Proposal: EN0110001 Keadby Next Generation Power Station Project.

Canal & River Trust Response Submission for Deadline Two (interested Party Number: [REDACTED])

Comments on Additional Information/Submissions received at Deadline 1

Indicative Workboat Location - Keadby  
& Stainforth Canal

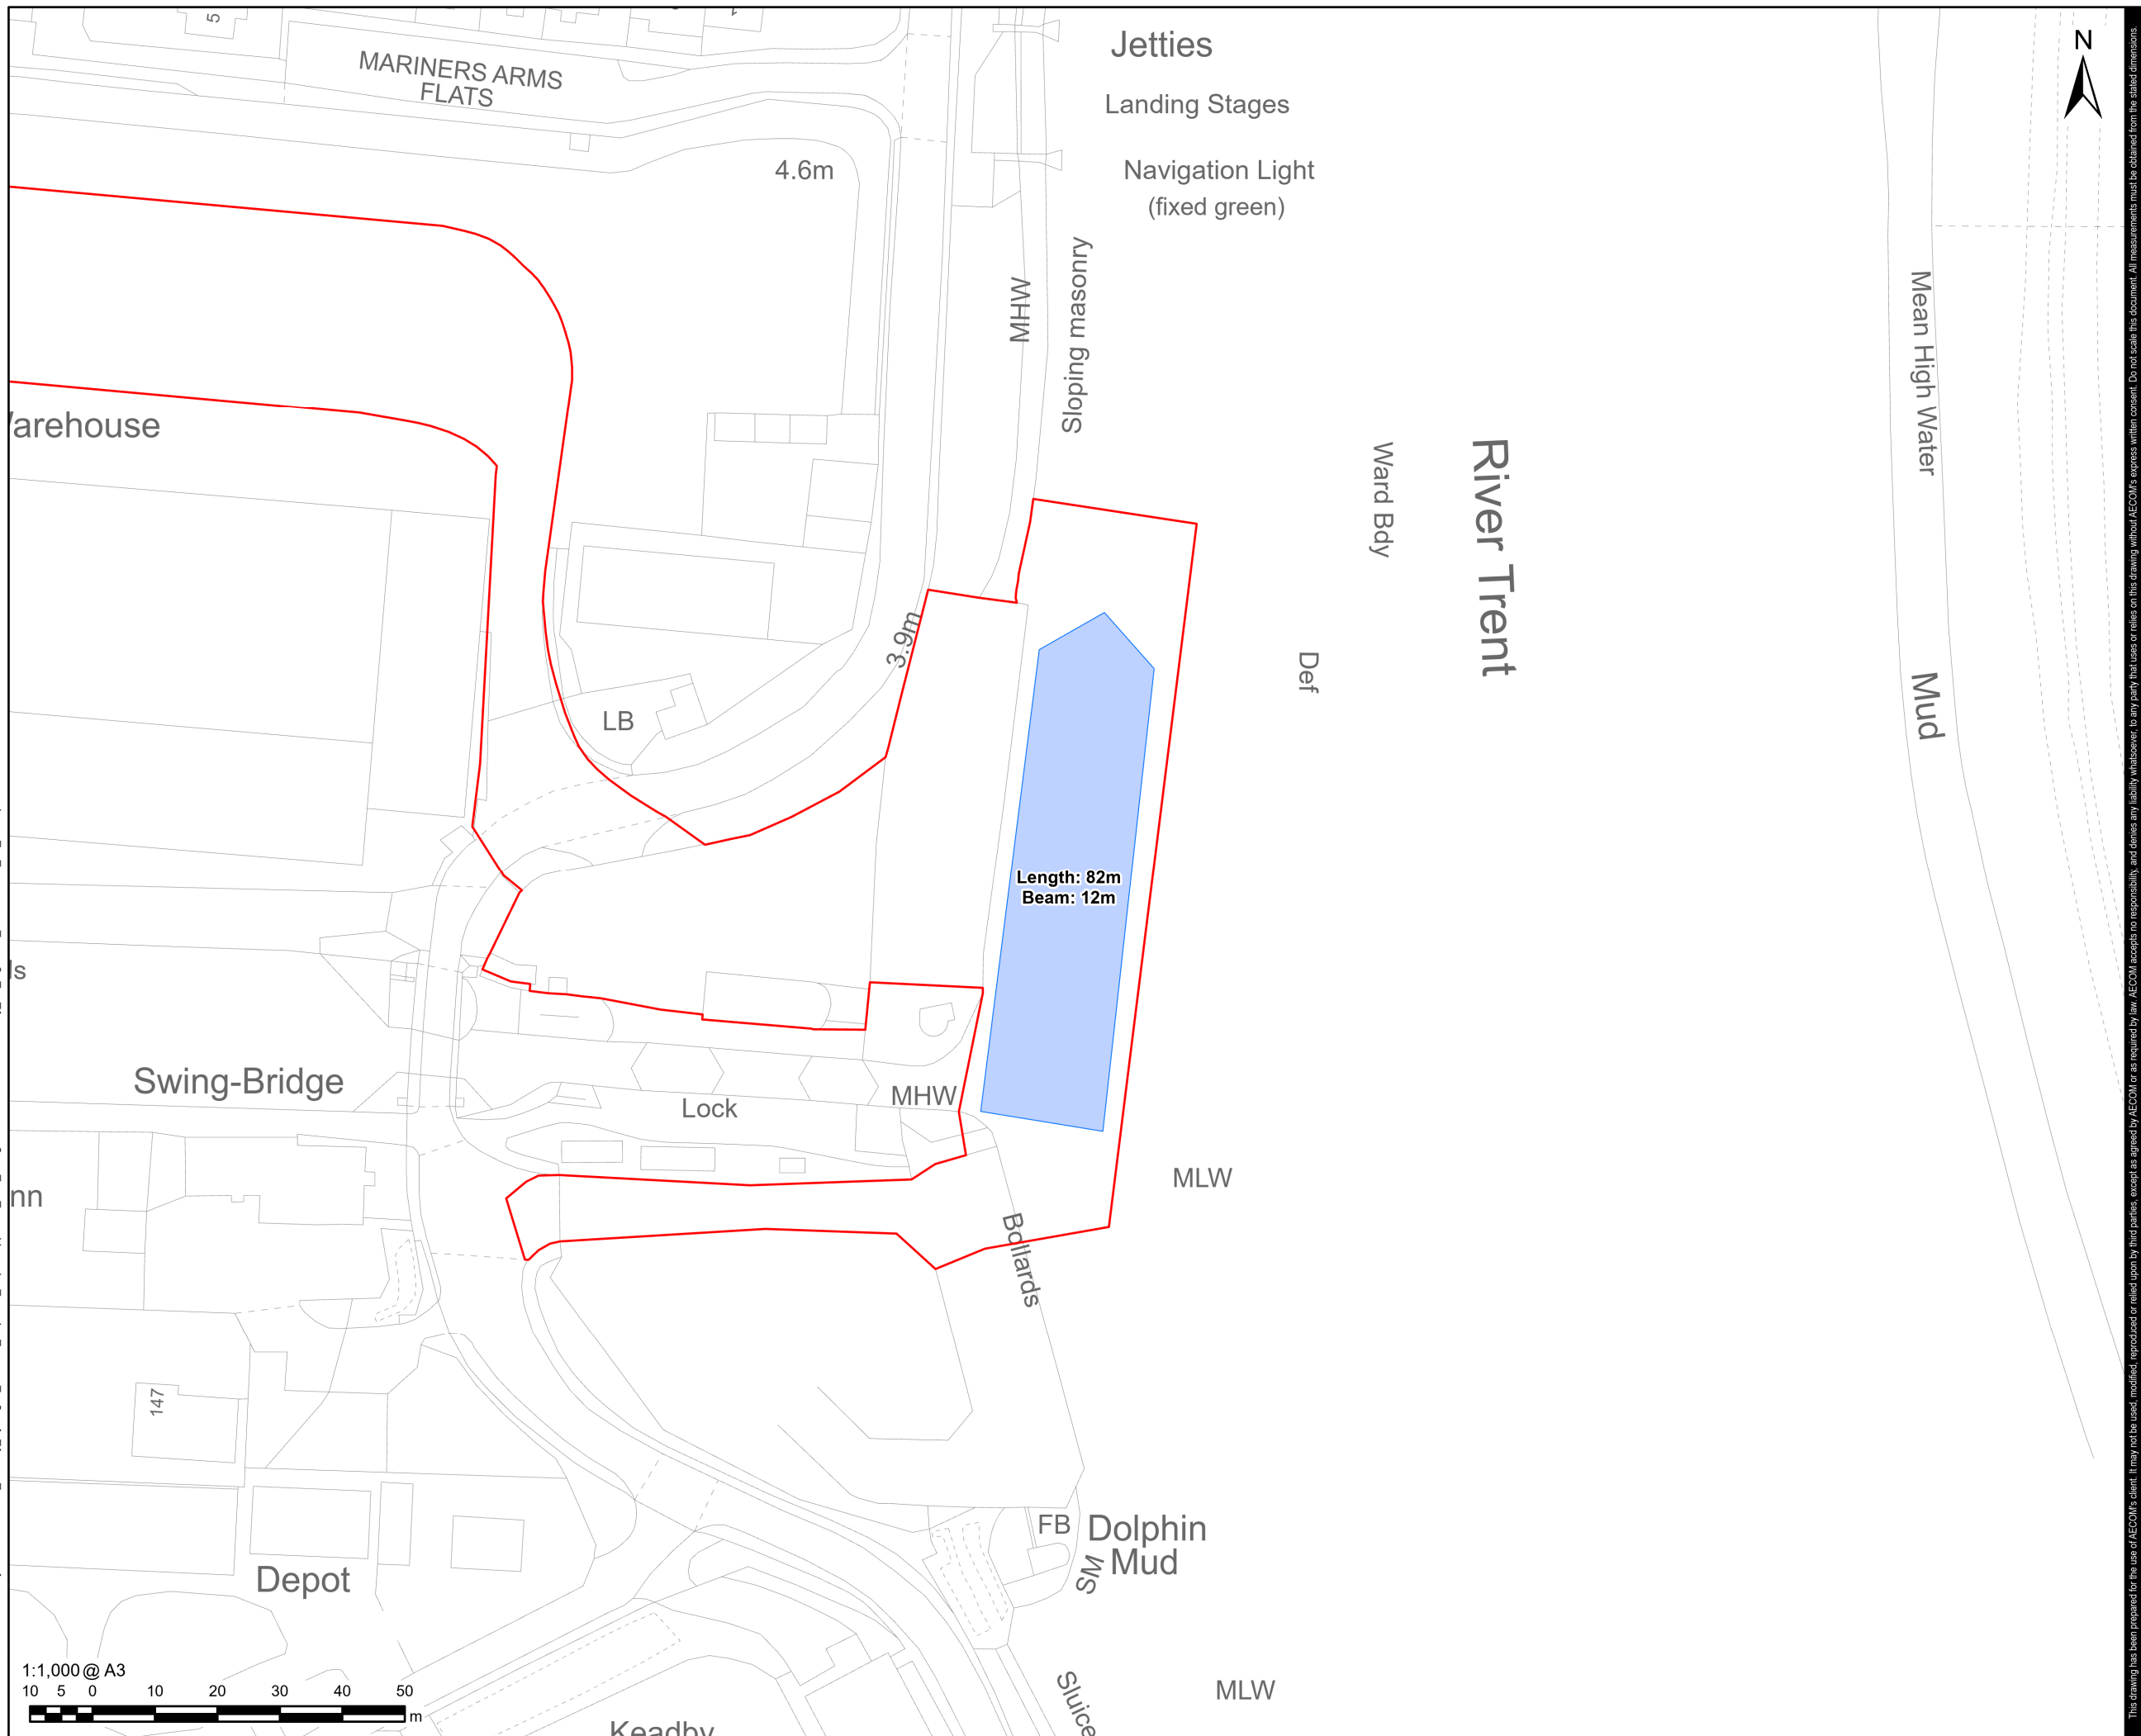
Our review of the Navigational Risk Assessment (APP-075) highlights that an error has been made in the assessment of the impact of the cofferdam works. Page 36 states that “on the basis of the limited ingress into the Canal (up to 20m for the total working area), it is considered that the navigable area between the southernmost extent of the cofferdam and the opposite bank of the Stainforth and Keadby Canal would be adequate to allow safe passage of vessels”. **We wish to highlight that a land take of 20m ingress into the canal would leave insufficient space for safe navigation.** As such, the conclusion of the Risk Assessment on this matter may likely be inaccurate.
